CITY OF ALBUQUERQUE

RE: ST. Martins Hospitality Center
Grading and Drainage Plan
Engineer's Stamp Date 2-3-2017 (File: J18D182)

Re: St Martins Hospitality Center Paving Project
1120 Second St.
Traffic Circulation Layout
Engineer's Stamp 02-03-17 (J18-D182)

GRADING AND DRAINAGE PLAN

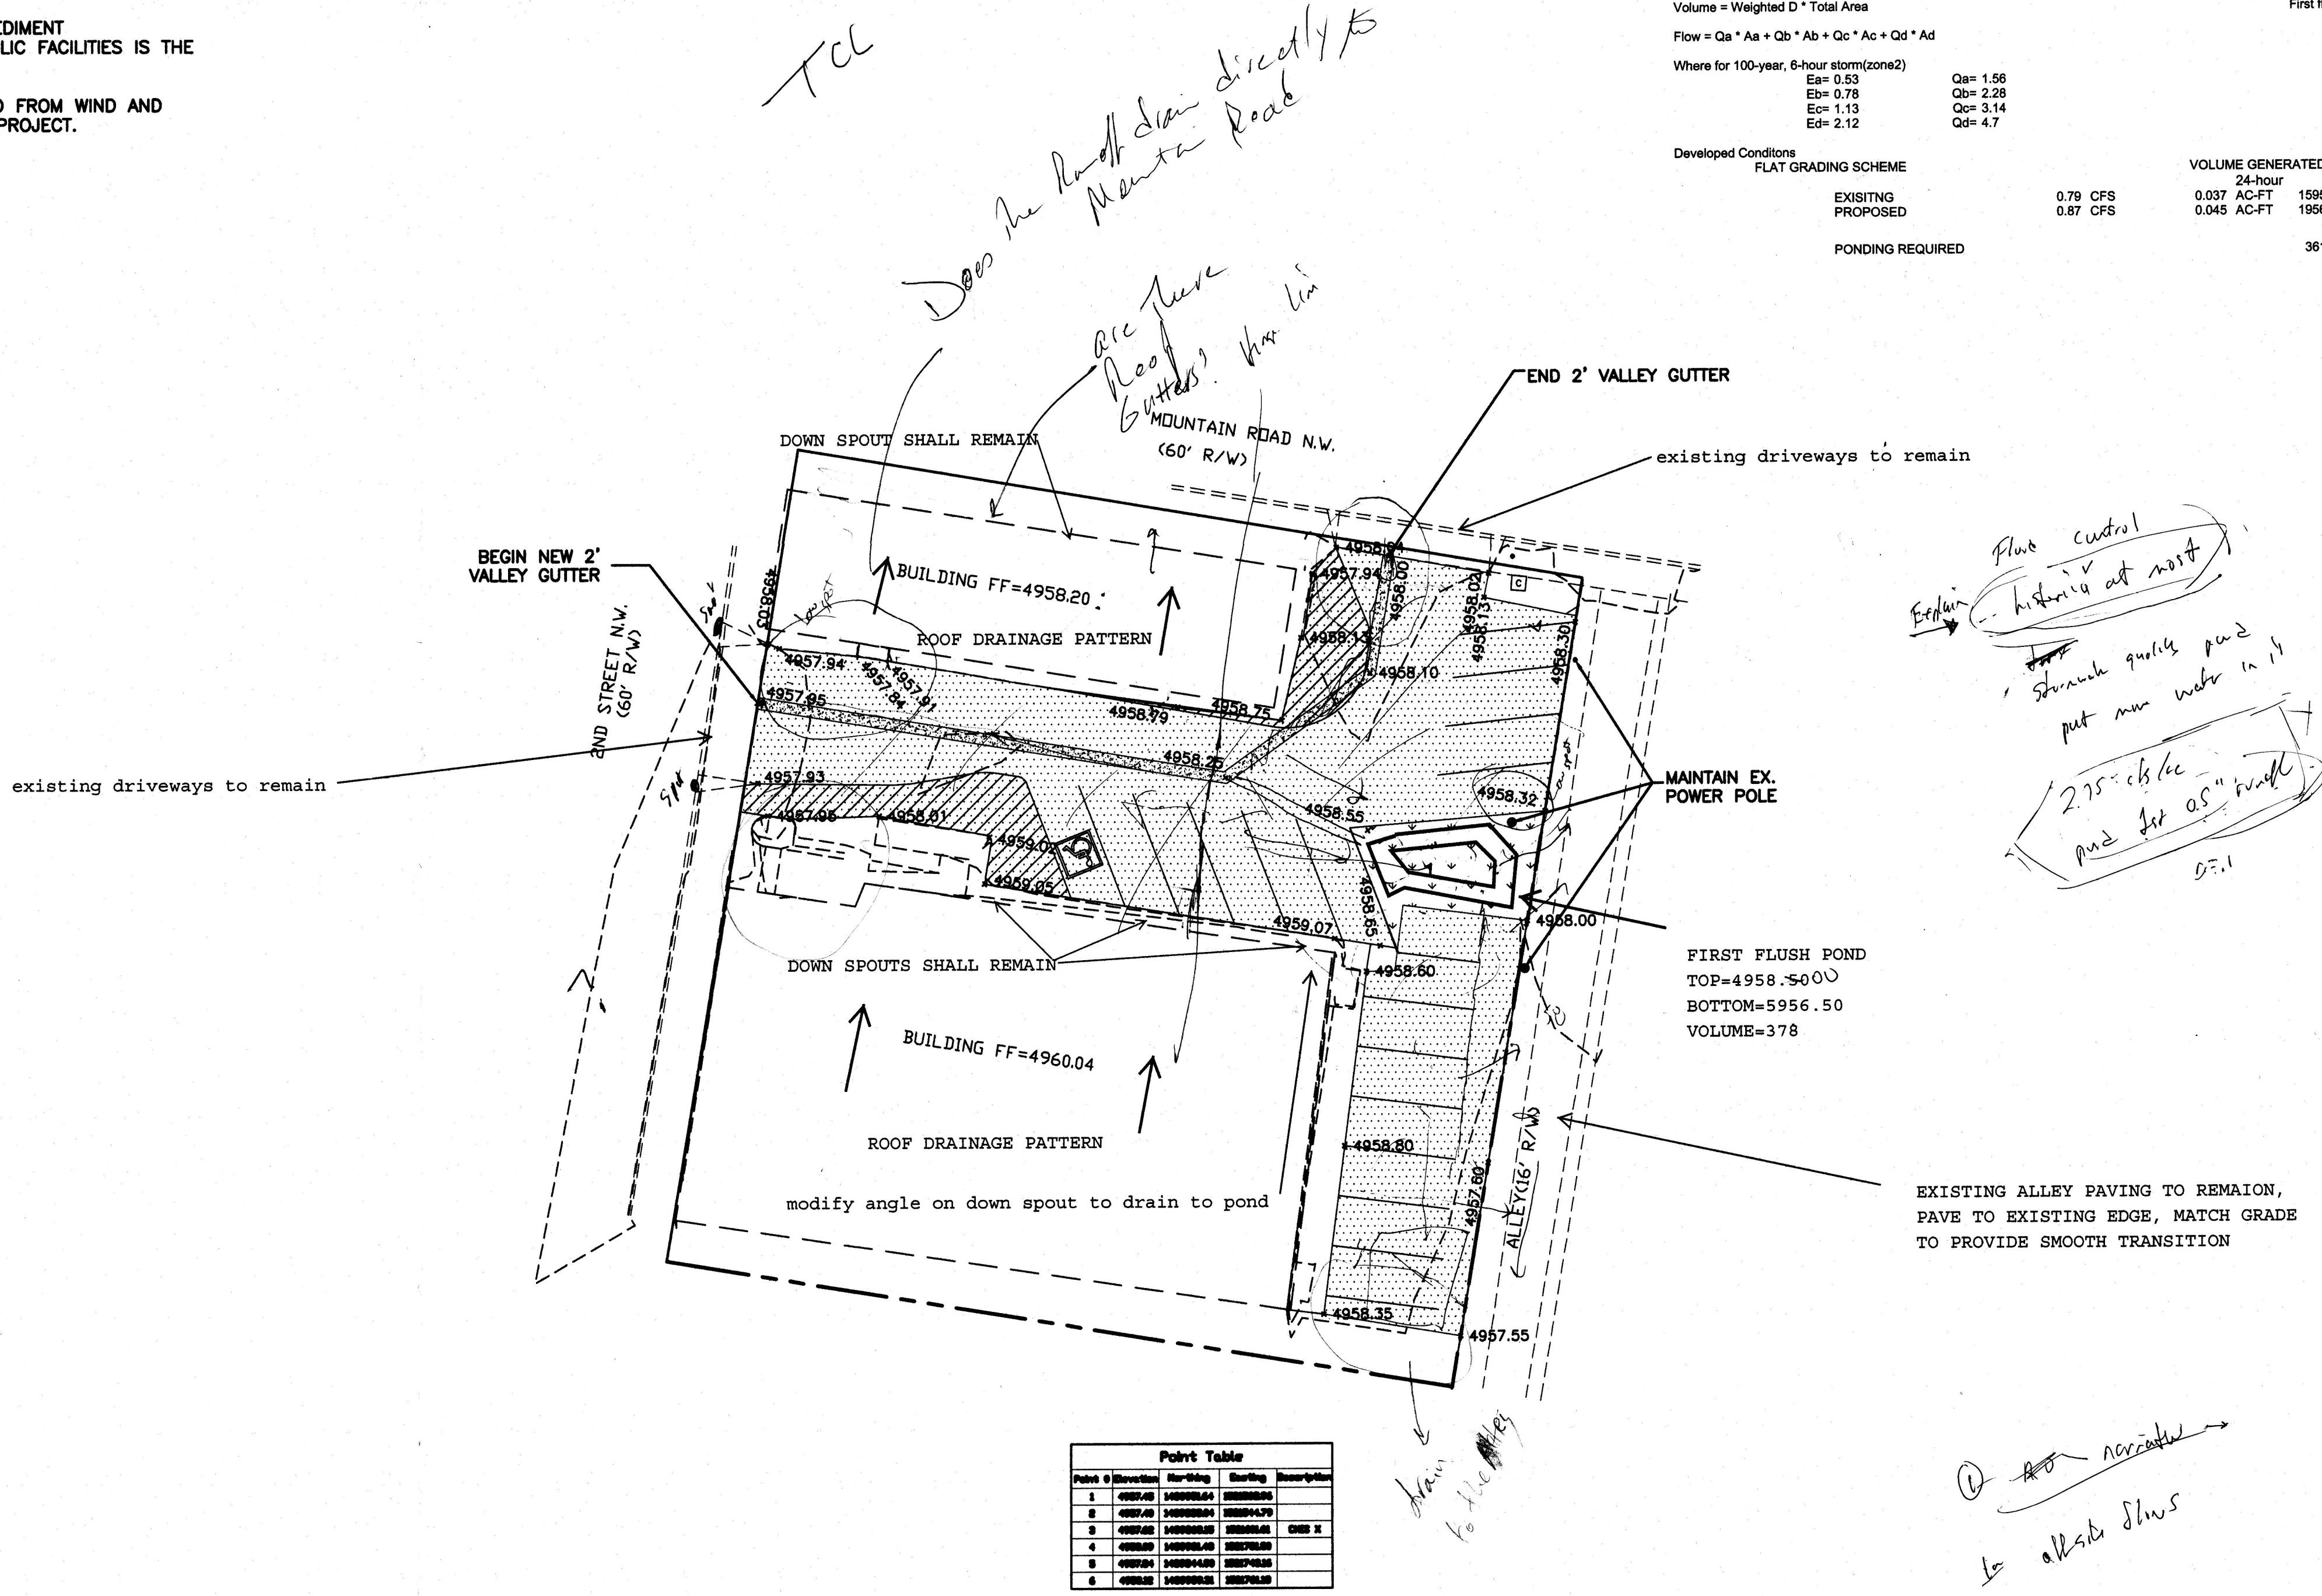
1. Provide onsite and offsite flow narrative.
2. Hinge line between the east and west side of the site will be beneficial to get half of the onsite runoff drain to the pond or make sure stormwater quality pond placed where flow can get to it.
3. Peak discharge for proposed condition should be the same or less than the existing conditions.
4. Does the northerly building roof drain directly to Mountain Road?
5. Is there a trash enclosure on site?

ENGINEER'S SEAL	ST. MARTINS	DRAWN BY WCWJ
	TRAFFIC CIRCULATION LAYOUT	DATE 2-03-17
2/3/17	 Rio Grande Engineering 1806 CENTRAL AVENUE SUITE 201 ALBUQUERQUE, NM 87106 (505) 872-0998	21703-LAYOUT-1-18-17
DAVID SOULE P.E. #14522		SHEET # JOB # 21703

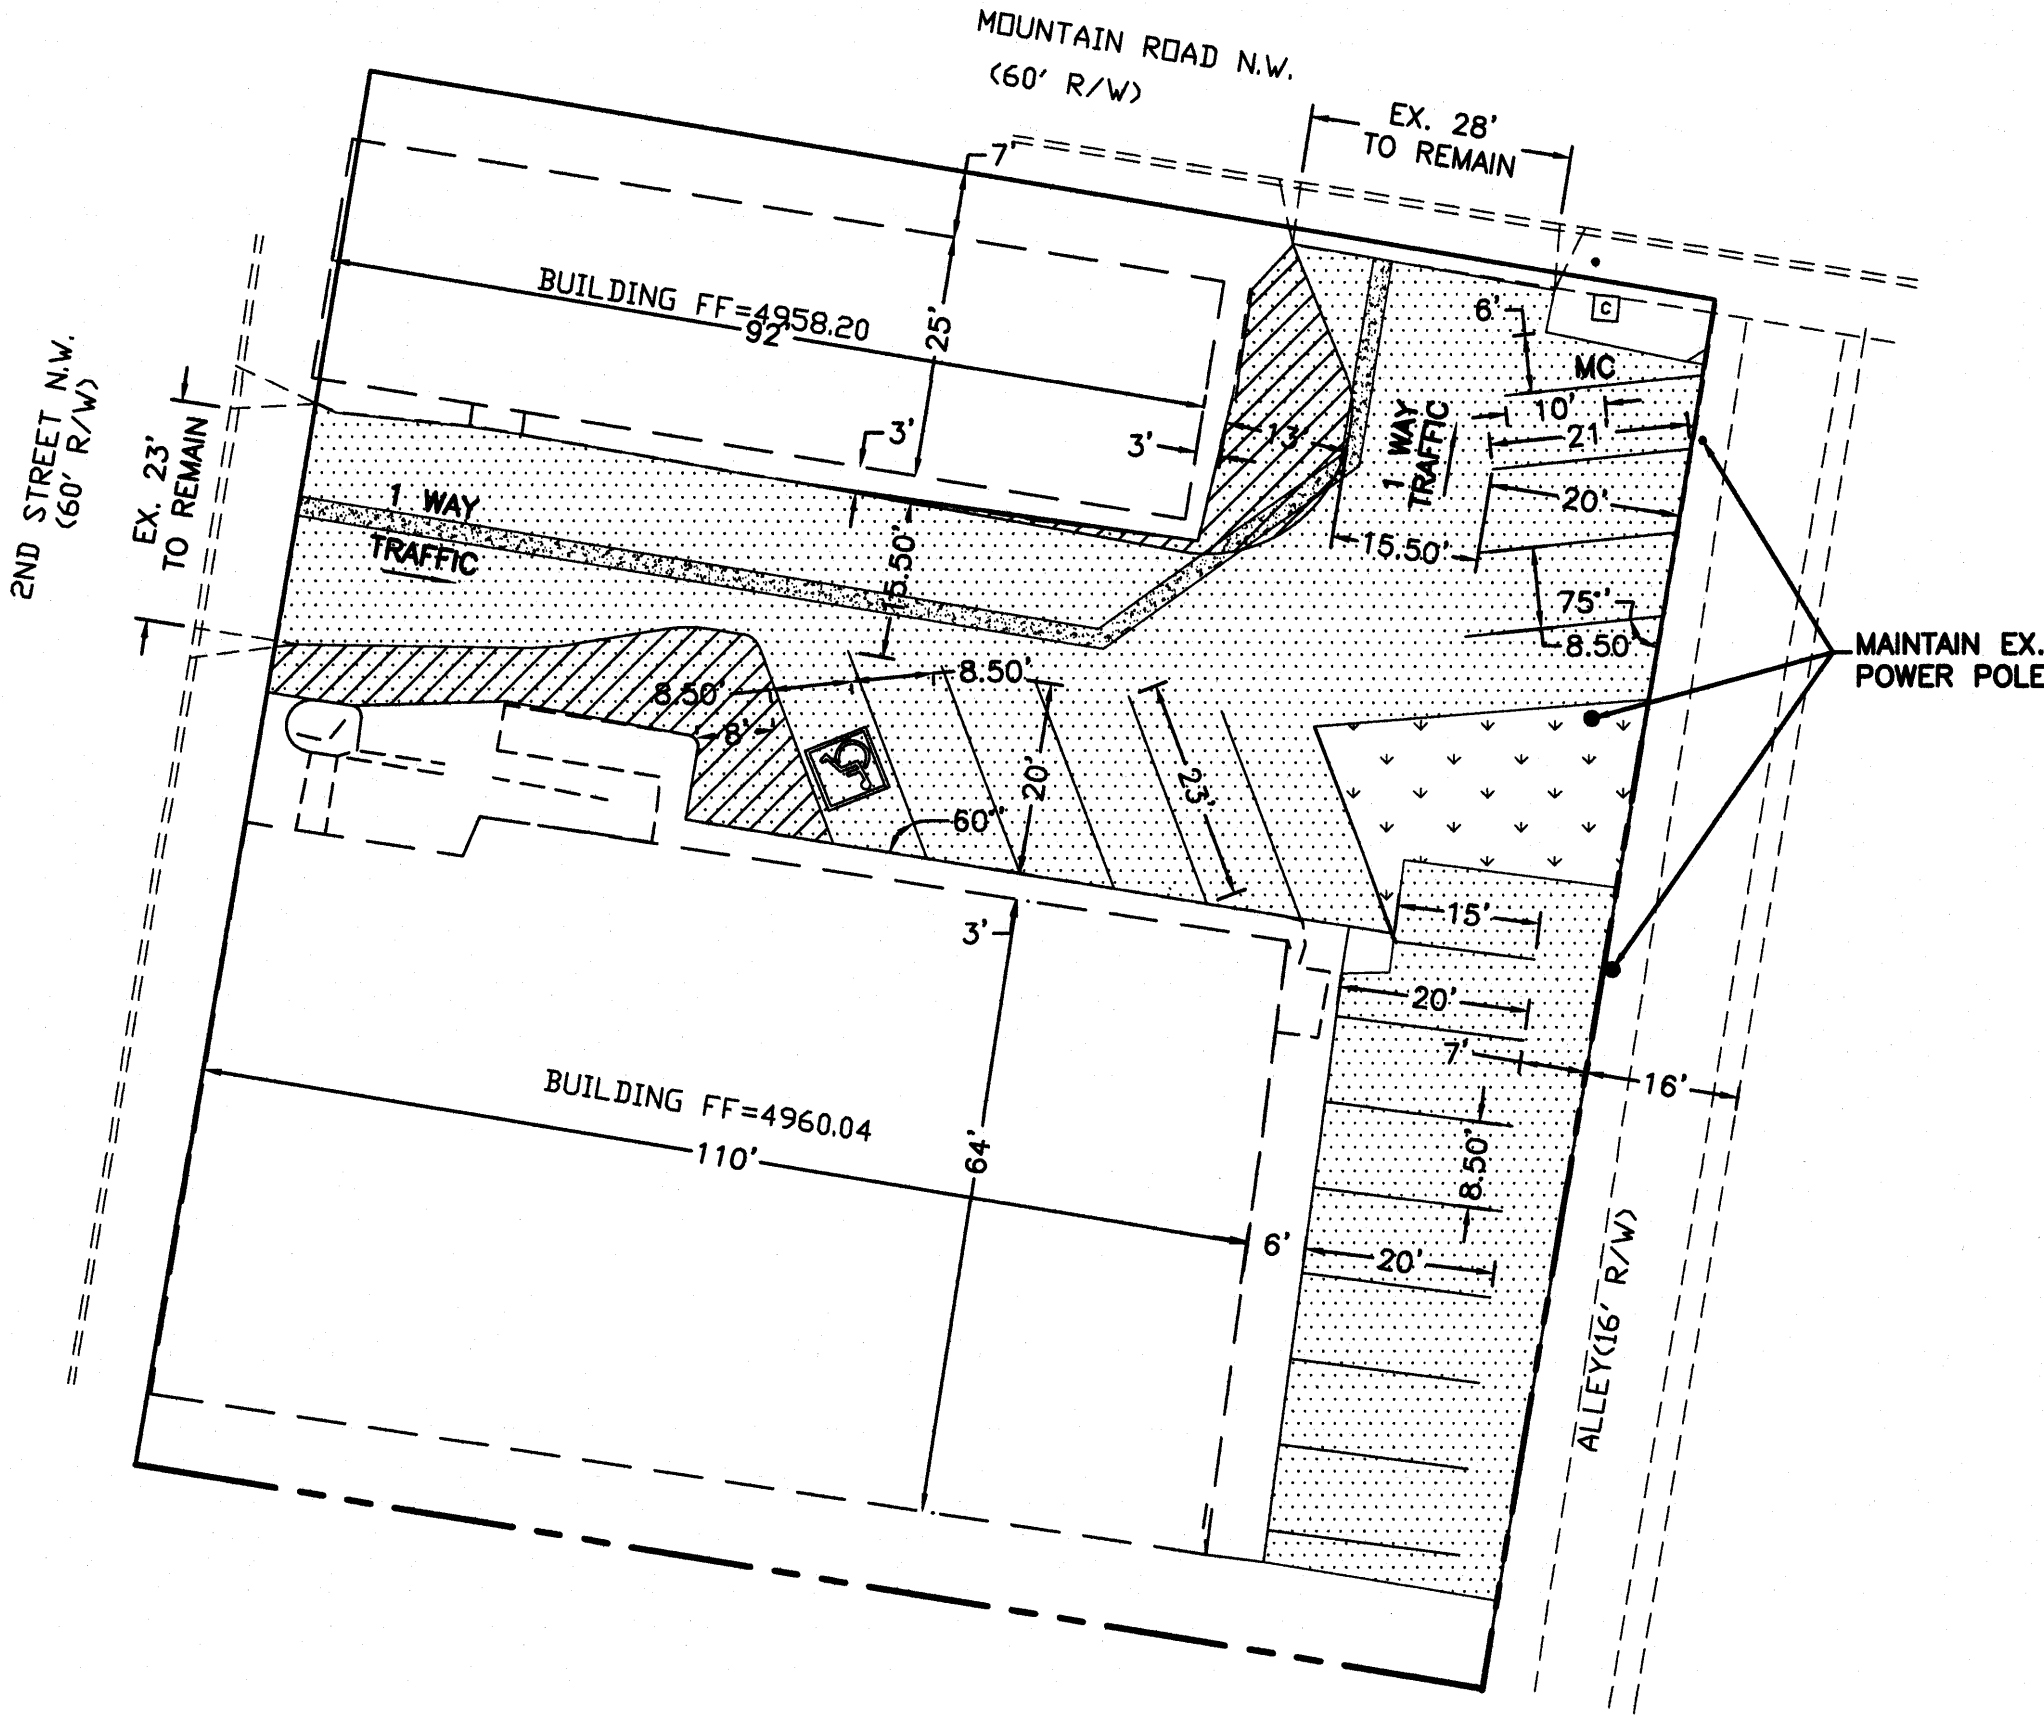
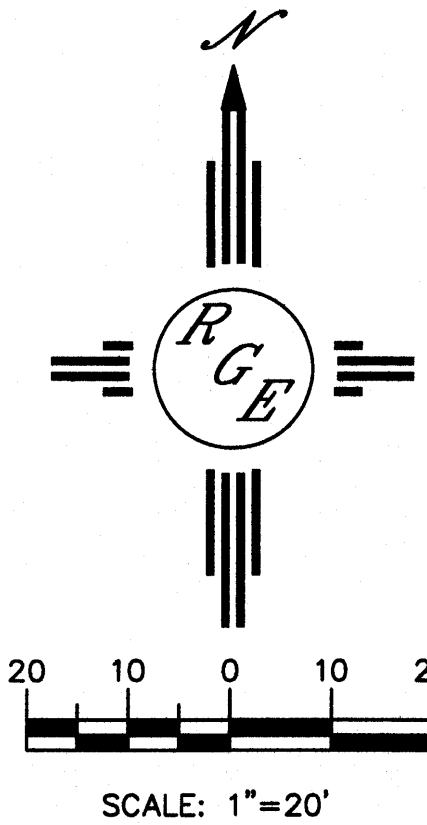
1. List the number of parking spaces required by the zoning code as well as the proposed number of parking spaces including bicycle and motorcycle parking.

2. Label the compact parking spaces by placing the words "**COMPACT**" on the pavement of each space.
3. The ADA accessible parking sign must have the required language per 66-7-352.4C NMSA 1978 "**Violators Are Subject to a Fine and/or Towing.**" Please call out detail and location of HC signs.

4. The ADA access aisles shall have the words "**NO PARKING**" in capital letters, each of which shall be at least one foot high and at least two inches wide, placed at the rear of the parking space so as to be close to where an adjacent vehicle's rear tire would be placed. (66-1-4.1.B NMSA 1978)

5. Per DPM, a 6 ft. wide ADA accessible pedestrian pathway is required from the HC parking stall access aisles to the building entrances. Please dimensions showing.

6. Provide a min 6" or max 8" high concrete barrier curb or other acceptable barrier between landscaping and parking areas and/or drive aisles. Please call out detail and location of barrier curb.

7. Service vehicle and/or refuse vehicle maneuvering must be contained on-site; provide a copy of refuse approval.
8. One-way vehicular paths require pavement directional signage and a posted "**Do Not Enter**" sign at the point of egress. Please show detail and location of posted signs.

9. The alley off of Mountain Rd NW should be paved. *STD DWG 2411 LP 02/14/2017*
